TfNSW Reference: SYD20/00719/02 (A36762396)

DPIE Reference: SSD-10473

**MARIST CATHOLIC COLLEGE NORTH SHORE MASTERPLAN – 264 AND 270
MILLER STREET, NORTH SYDNEY**

TfNSW has reviewed the submitted application and requests the following additional information for further assessment:

Figure 10 – Proposed bike parking locations at basement level

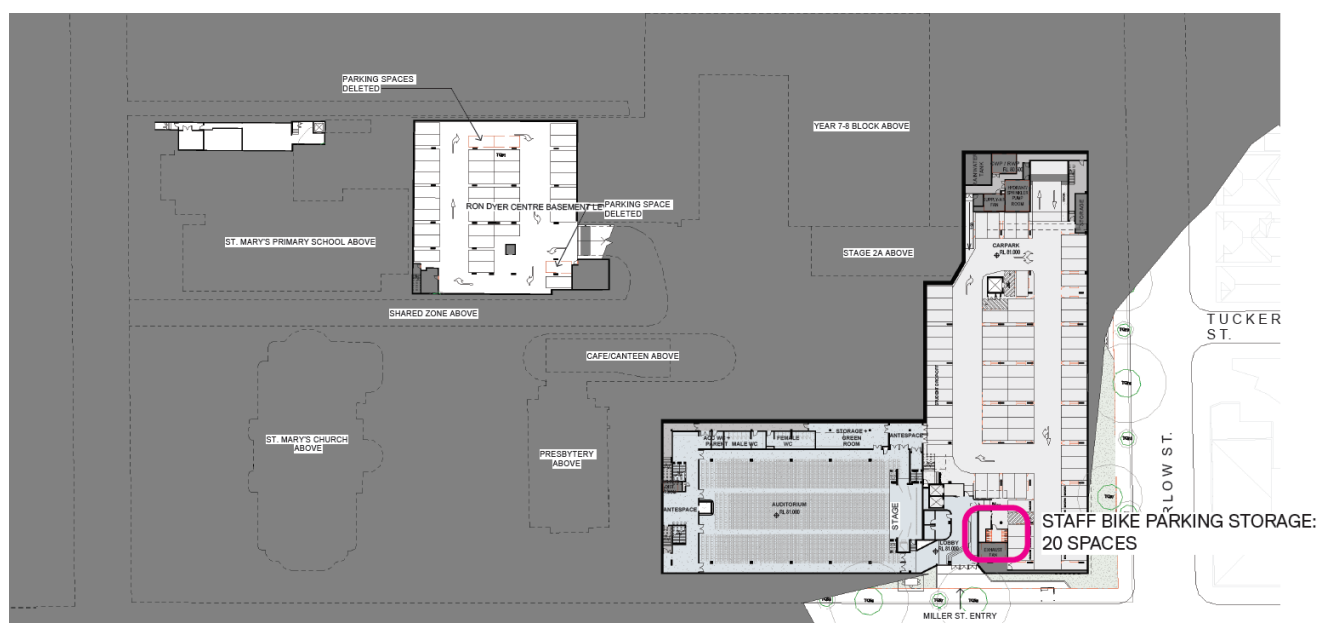
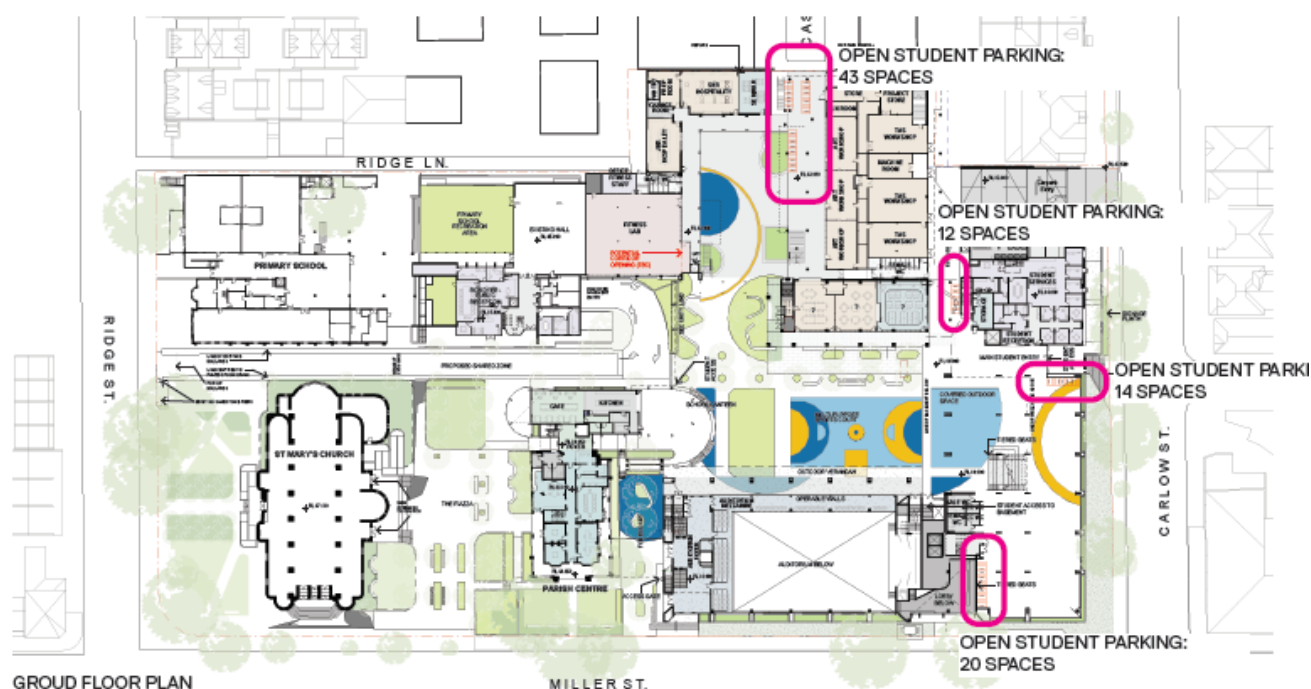
- 89 bicycle parking spaces for students and 20 bicycle spaces for staff. Locate bicycle parking and storage facilities in secure, convenient, accessible areas close to the main entries incorporating adequate lighting and passive surveillance and in accordance with Austroads guidelines.
